XQLA Design Review

Land South of Barugh Green Road and East of Higham Common Road, Barnsley
(Barnsley West)

8th February 2024 – Landscape notes on Design Matters

**S5**  
0226  
**SHORT SECTION 5**  
Scale 1:250 @A1

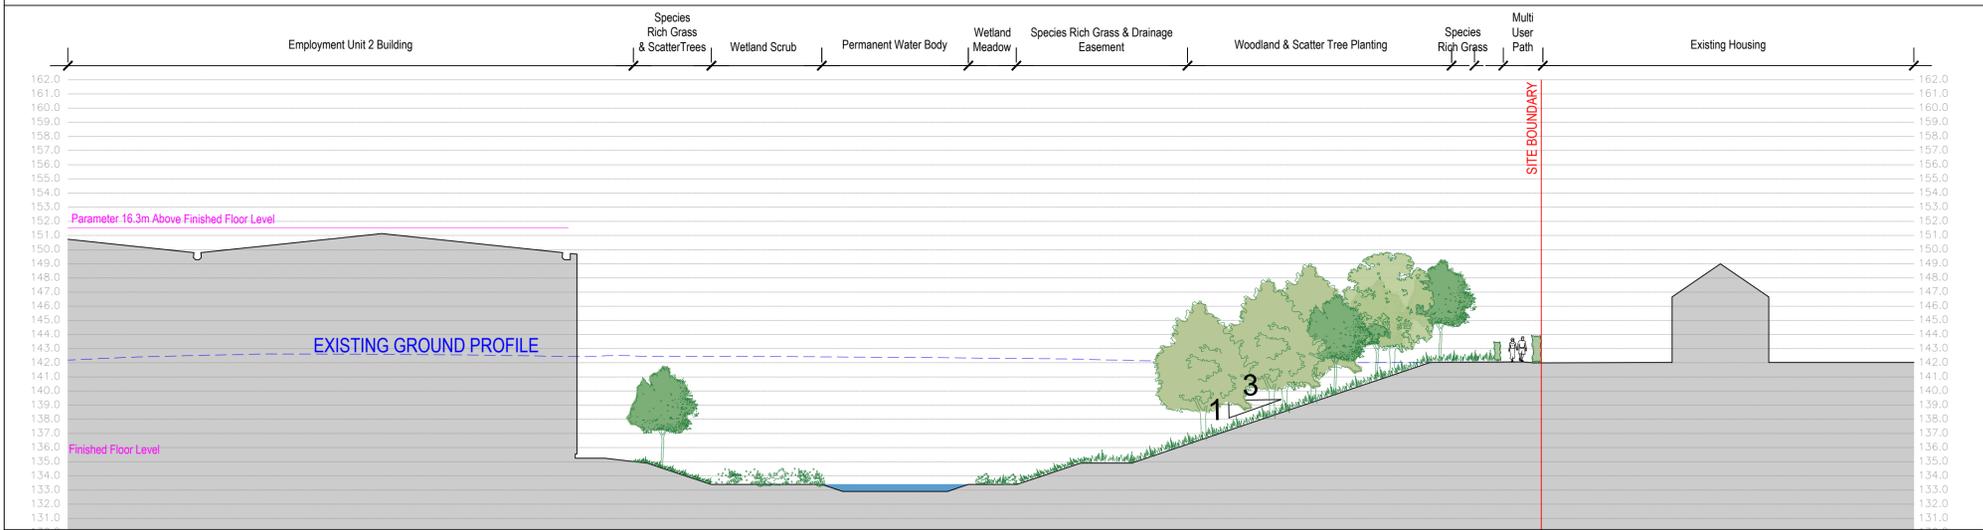
The Active Travel route running along the south-eastern boundary, in the vicinity of the employment units is flanked by a retaining wall on one side and land mounds on the other. This may therefore lead to a confined walking experience, (as illustrated in Short Section 05- PI 1754-00-001-GIL-0226). Whilst the use of natural buffers such as landscape mounds and implementation of levels strategy is realised to be critical to mitigate landscape visual impact, this should be integrated with the functioning of the routeways through the site and maintain a comfortable visibility/ sight distance.

**S20**  
0226  
**SHORT SECTION 20**  
Scale 1:250 @A1

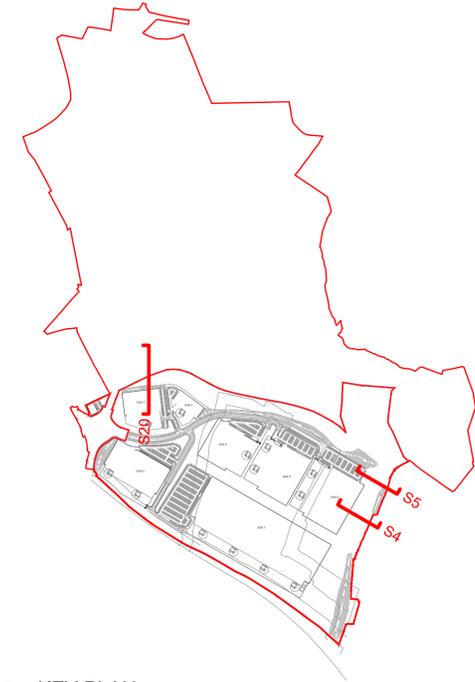
To mitigate this visual impact, a higher density of larger planted tree sizes should be proposed amongst the typical whip planting and shrubs increasing the screening effect of the visibility mounds demonstrated on section S20:226-unit 7 building. Moreover, considering the large scale of these structures, well-integrated landscape spaces are required for the employment area to function cohesively in the context of its residential neighbourhoods in the immediate surrounding, as well as for the community using and working in the employment facilities.
